Our Ref: A/165/19/DOC

Approval of details reserved by condition imposed under ref A/74/18/OUT relating to Condition Nos 4 - acoustic, 5 - external lighting, 7 - contamination, 12 - hedgerows, 14 - surface water drainage, 15 - discharge of flows, 16 - SuDs and 18 - watercourse or culvert.

The Laurels Dappers Lane Angmering BN16 4EN

Arun District Council have decided to **REFUSE details reserved by condition for the following reasons:**

**Project:** Oceanview Developments  
**The Laurels**  
Dappers Lane  
Angmering  
**Title:** Proposed Drainage Strategy Plan

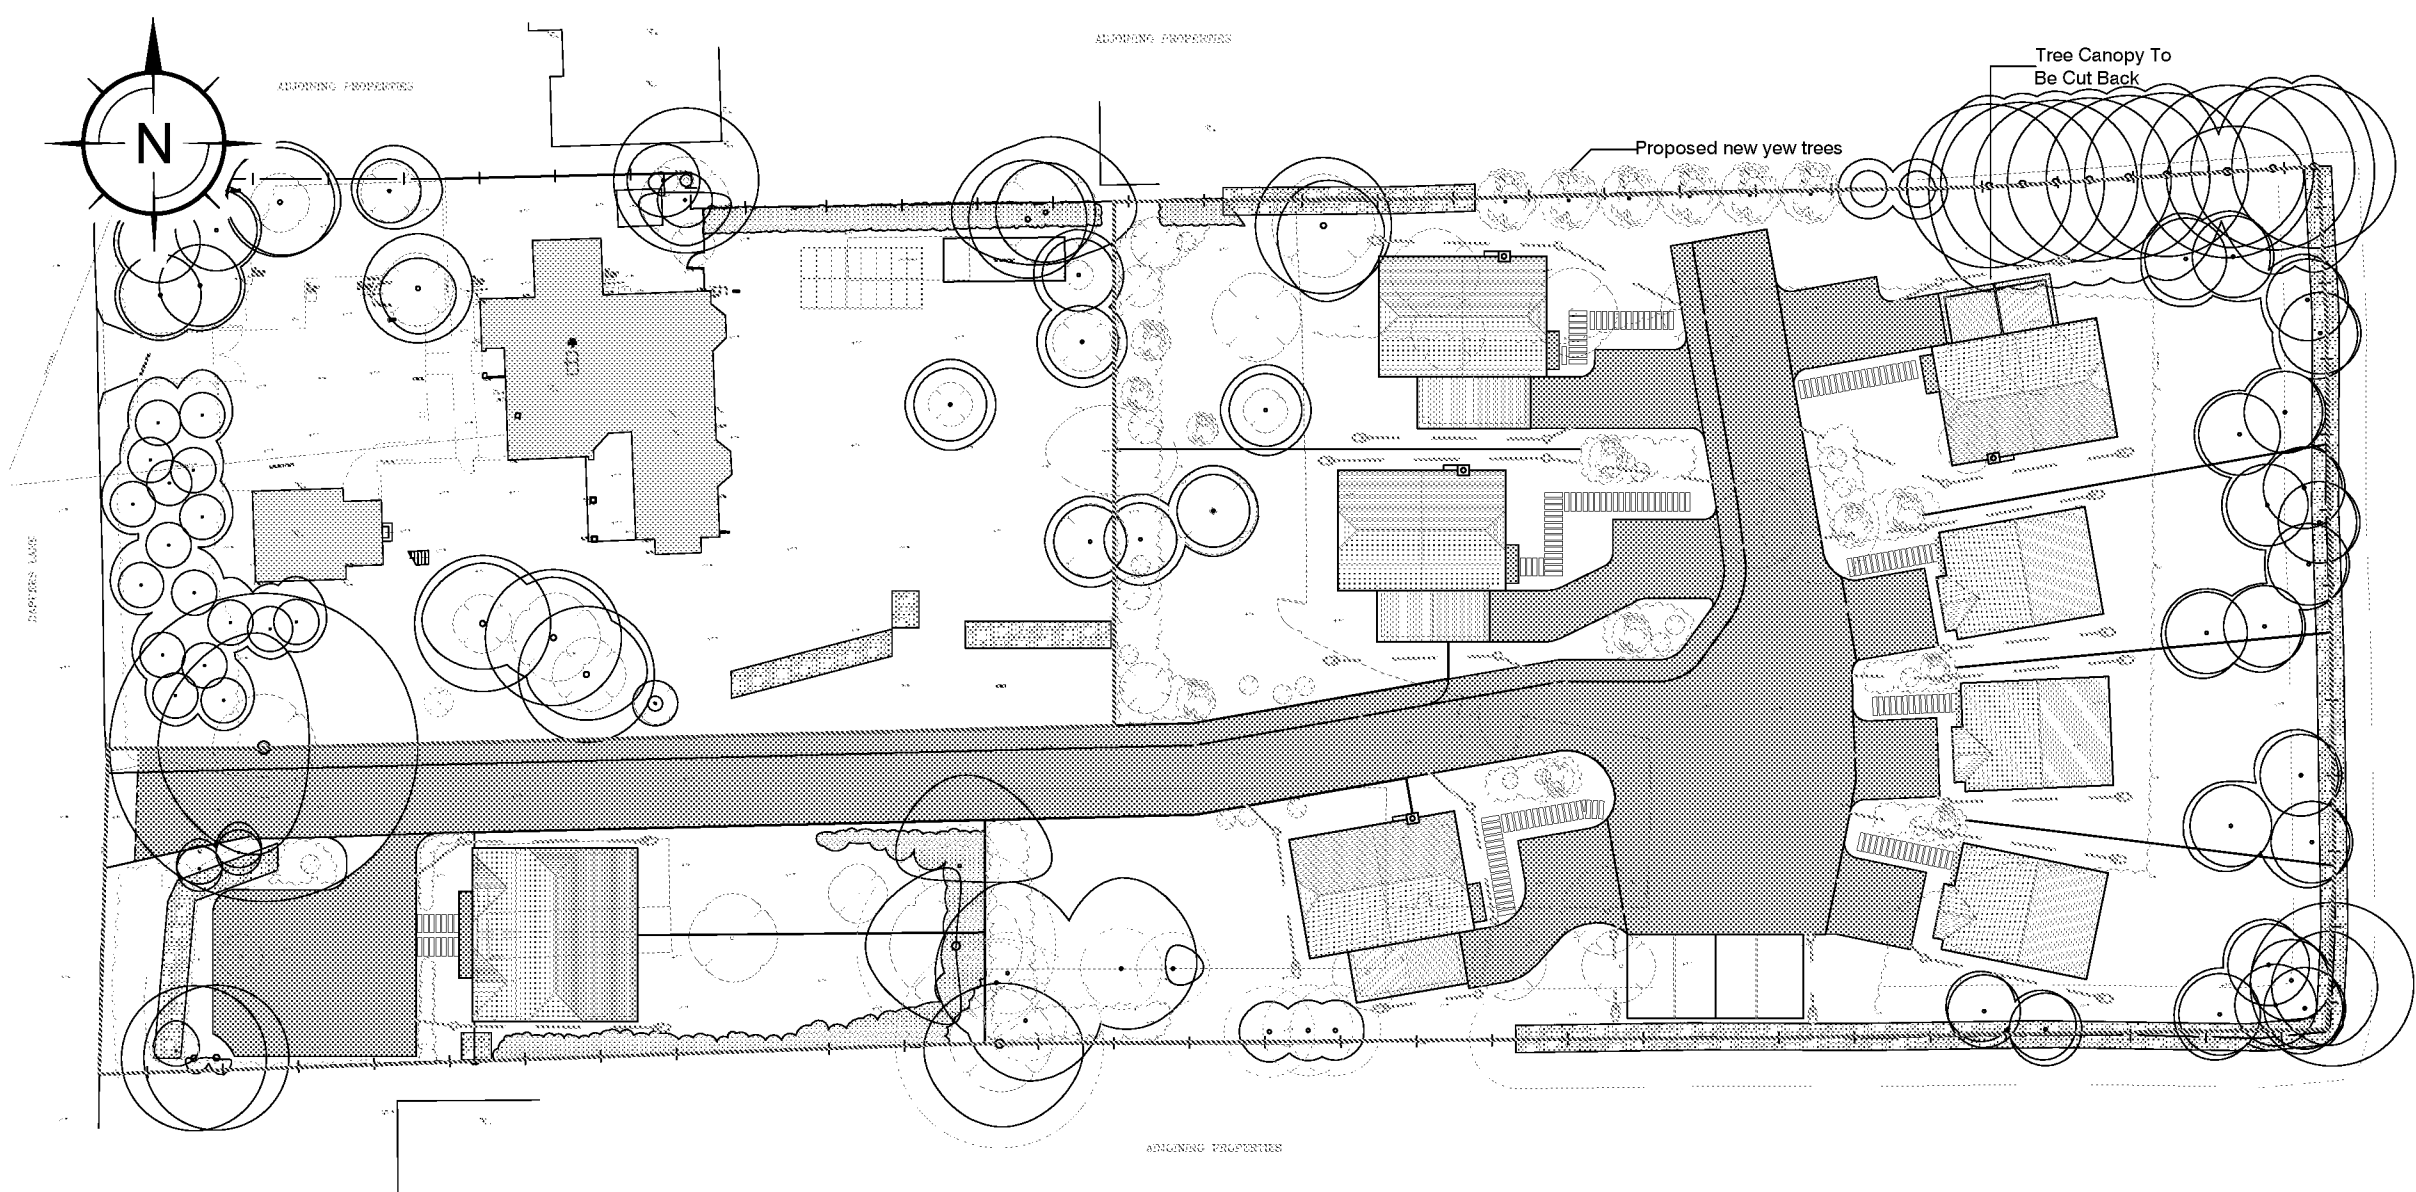
The applicant appears unaware that a culverted watercourse runs along the western boundary. The following details should be provided so further comments can be made;

- a) A plan showing its location.
 - b) Position/photos of any existing manholes on the culvert adjacent the site including immediately upstream/downstream.

- c) Manhole/culvert invert levels/cover levels.
 - d) Pipe diameter/material.
 - e) An internal CCTV survey inspection.
 - f) Proposed finished levels above the culvert.

5. Whilst permeable paving is likely to be the way forward, due to the lie of the land, the design will need to ensure that water does not all run to the lower end of the site via the sub base, so the paving will need to be compartmented to ensure that water is contained within each structure. This arrangement will need to be fully detailed in terms of construction details and proposed finished/bed levels and supported by storage/infiltration calculations for each section. Please note that on the example calculation sheets, a porosity value of 0.95 has been used. Whilst this is acceptable for permavoid blocks, granular stone should be 30%, so the calculations will need to reflect the construction of each specific section of permeable paving. Where stone is to be used, this is to be type 3 material (of specified grading/no fines) wrapped in a permeable membrane.

Soft Landscape Layout
The Laurels, Dapper's Lane, Angmering, West Sussex.

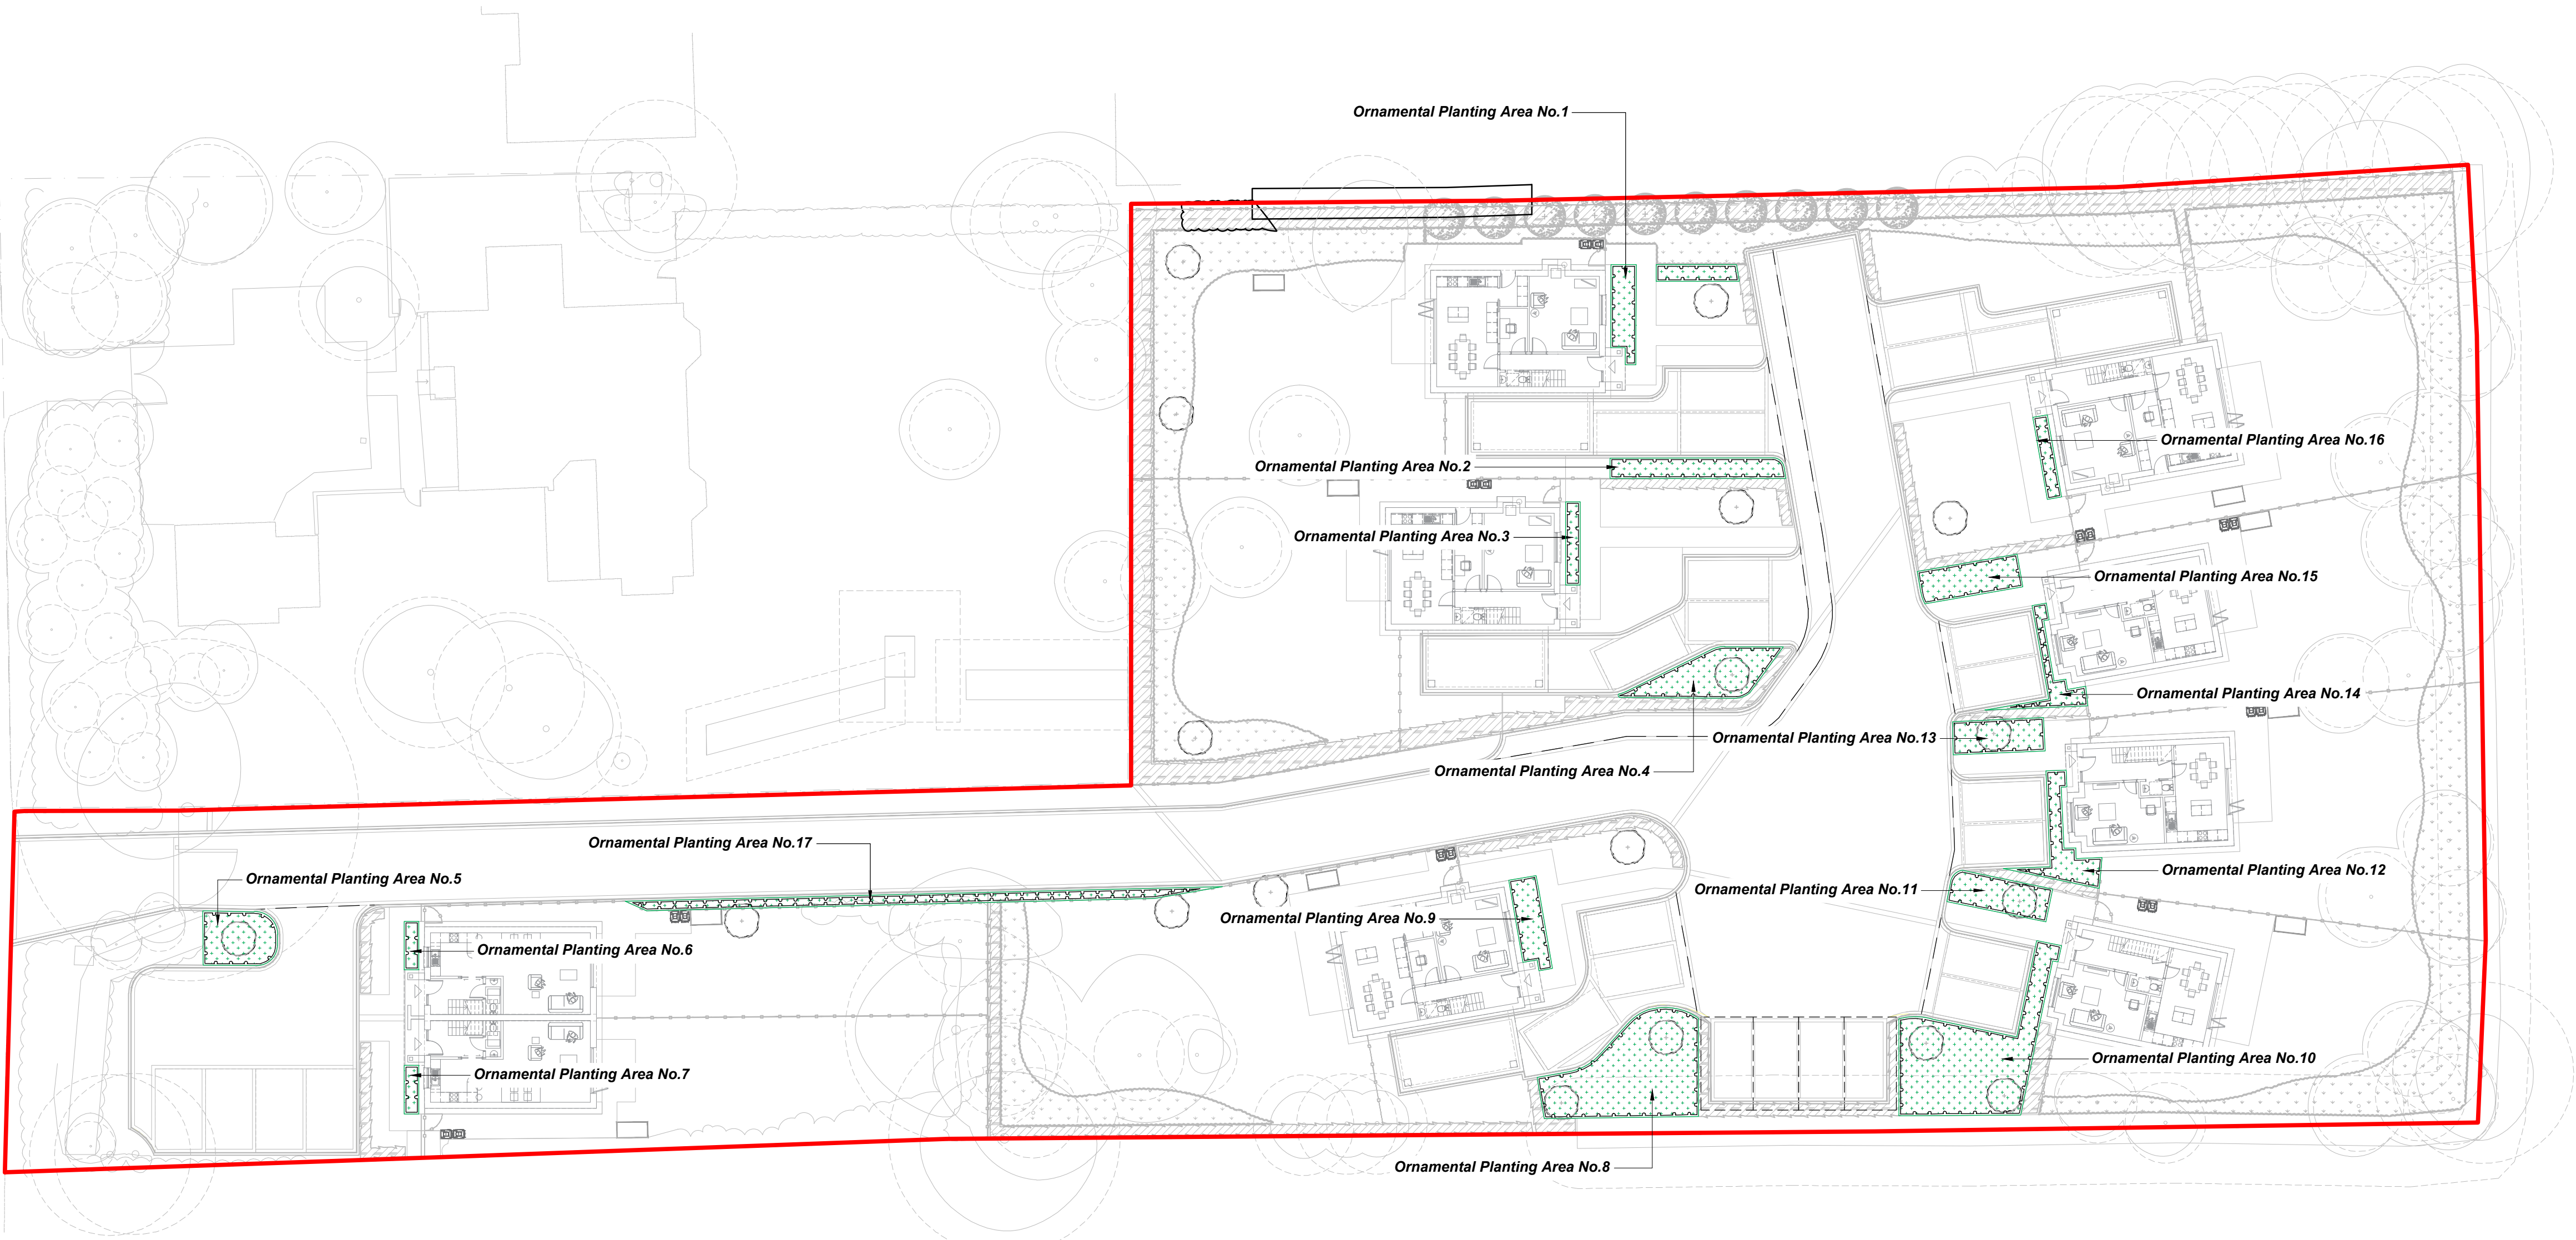
- g) No new tree planting to be undertaken in the vicinity of the culvert. This needs to be made clear on the drawings.
2. Provide a fully detailed foul drainage proposals plan.
